A/109/21/L

Church House Arundel Road Angmering BN16 4JS

Listed building consent for the replacement of 5 No. windows on front elevation and rebuild of flint boundary wall.

Five replacement sliding sash windows on Front elevation

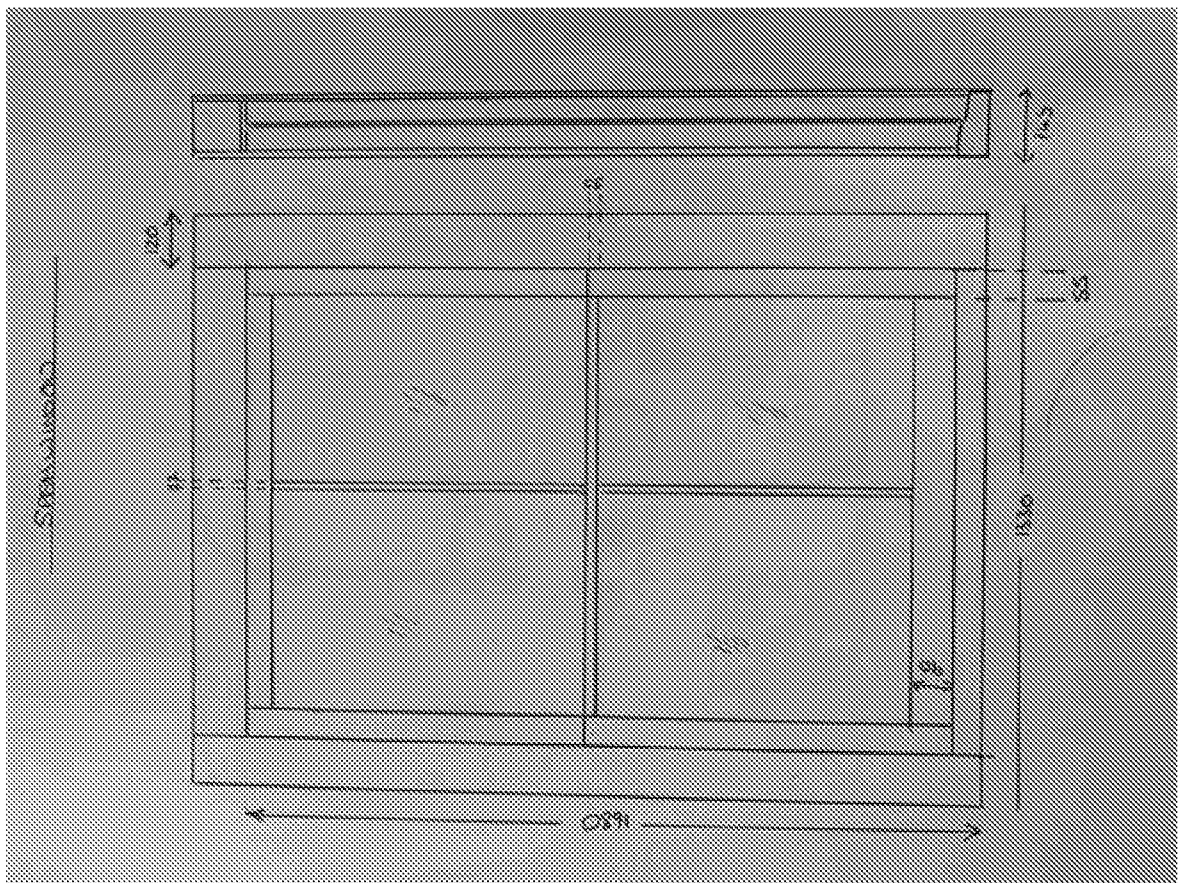
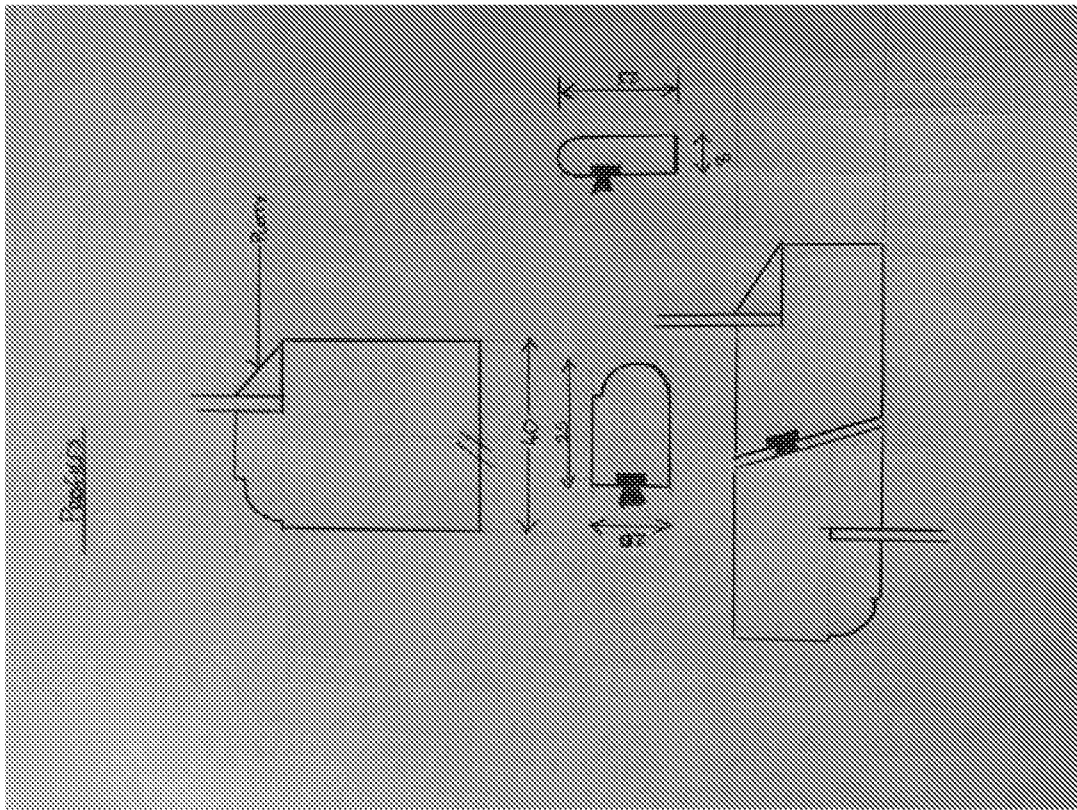
The applicant identifies that the timbers of the sash windows are significantly decayed and that repair is not worthwhile (i.e. they are beyond salvage). The windows have very limited historic material and no historic glazing. Whilst the details of the proposed window are acceptable, it would help to understand how the glazing bar is to be treated – it should be integral to the frame, and not applied.

The section of flint wall to be re-built.

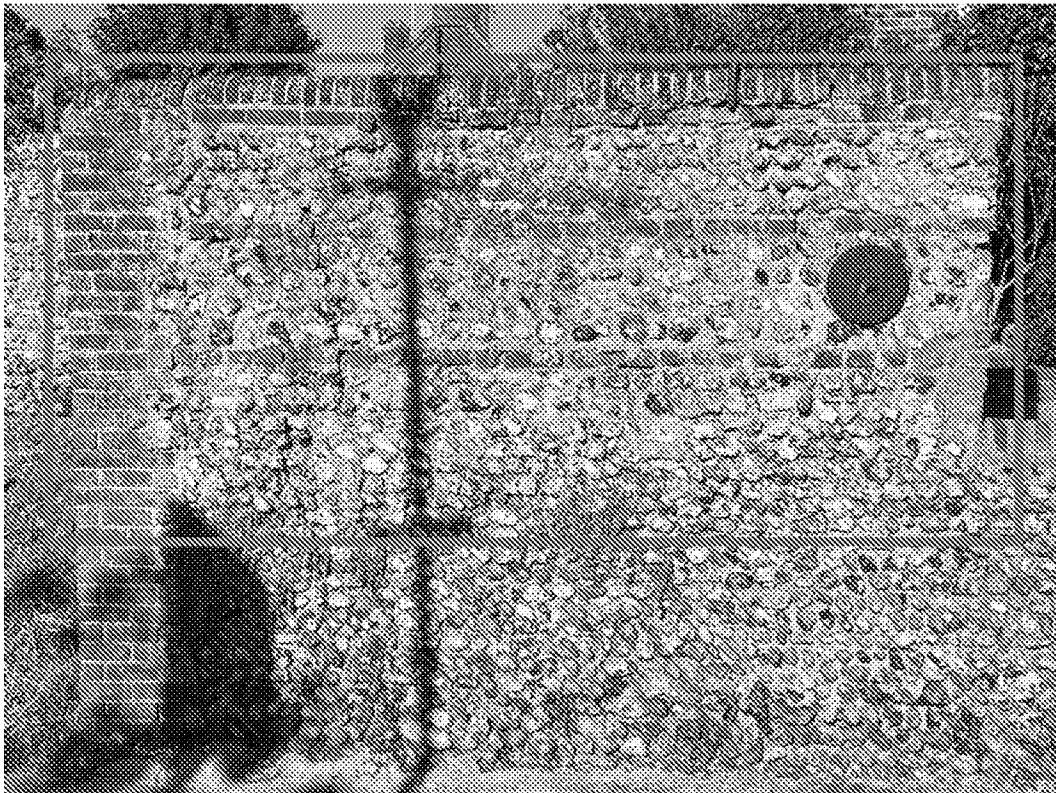
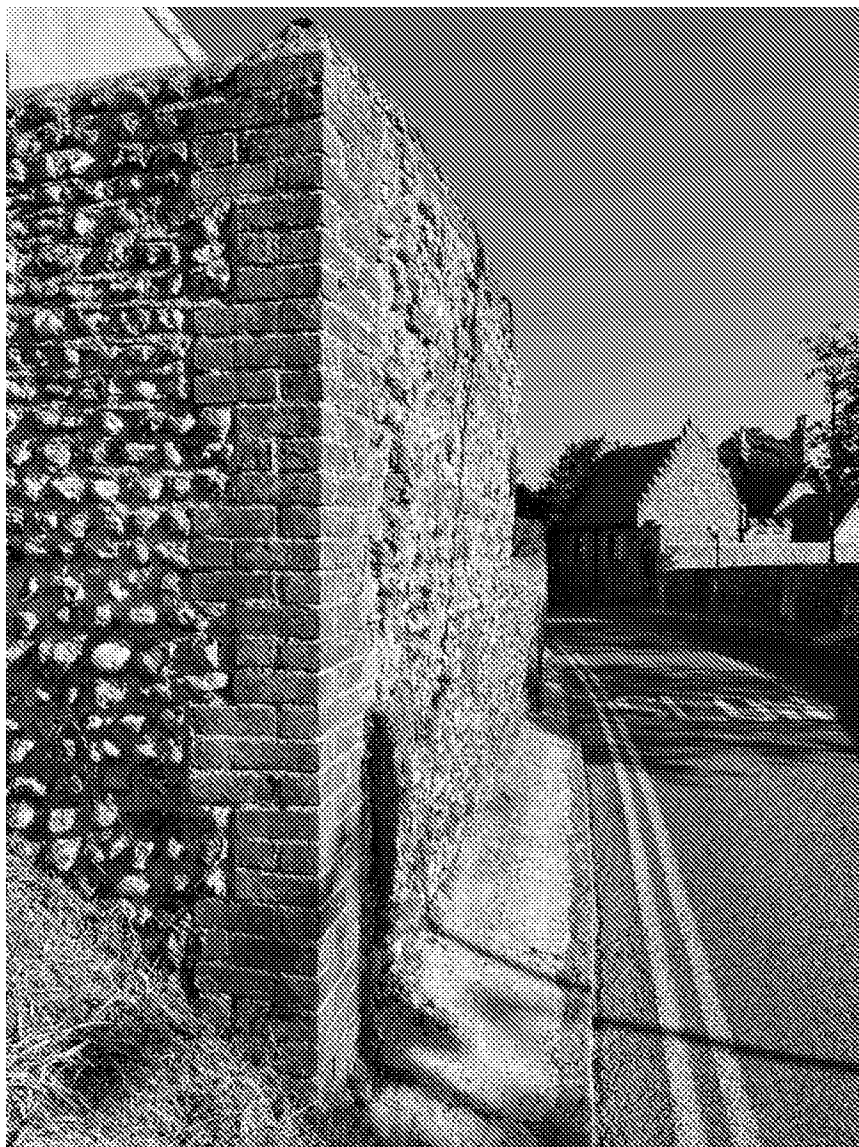
Likewise, the applicant identifies that the section of boundary wall leans by more than 1/3 of its thickness and mortar joints are worn, eroded and losing adhesion. The proposal to rebuild the section of walling will ensure that it is put into a good state of repair and its presence maintained. The concept of saving the existing materials and matching the existing lime is positive. The location of the wall is such that it can be clearly seen from the neighbouring road and public open space, and as a result, the quality of the new build should be high. I believe that the works will not harm the significance of the wall, but that a sample panel should be provided prior to the re-build commencing. This will ensure that it reflects the existing quality of the wall, whilst also not affecting its significance.
